Development Control  
Ribble Valley Borough Council

**App no: 24.0667**

**Address: Ground floor Unit 5b Abbey Works King Street Whalley**

**Proposal: Regularisation of unauthorised change of use to bar and music venue.**

Location Plan
Site Address: Salvage House, Unit 5b, Abbey Works, King Street, Whalley, BB7 9SP

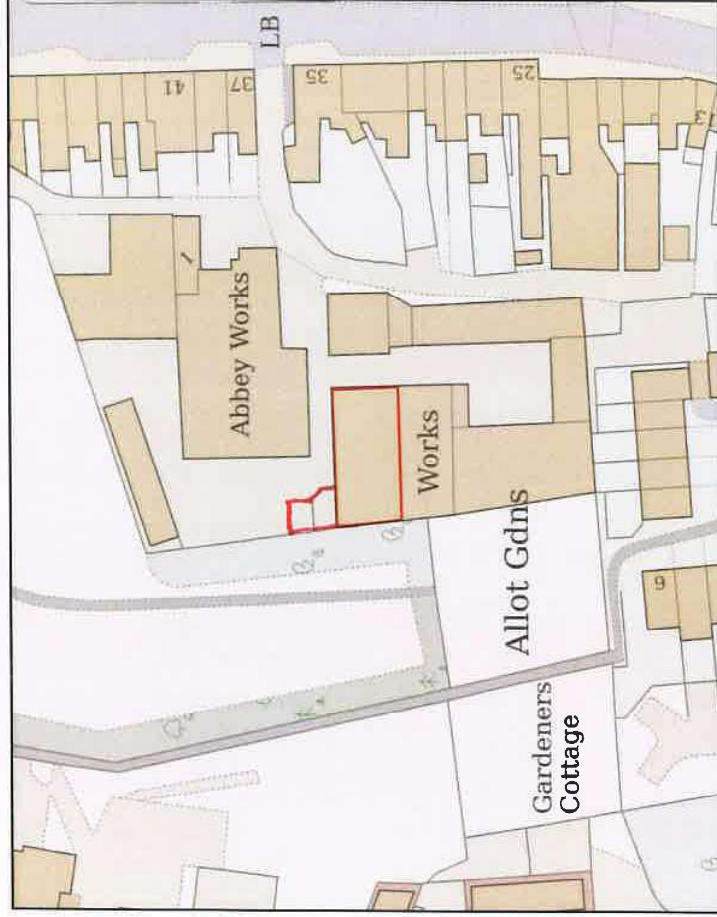
The edge has been amended to include two car parking spaces associated with the building. The edge should include the access and extend to King Street.

There are two car parking spaces included within the red edge. There are two rooms for hire on the ground floor in addition to the bar/restaurant and a taxi booking office on the first floor.
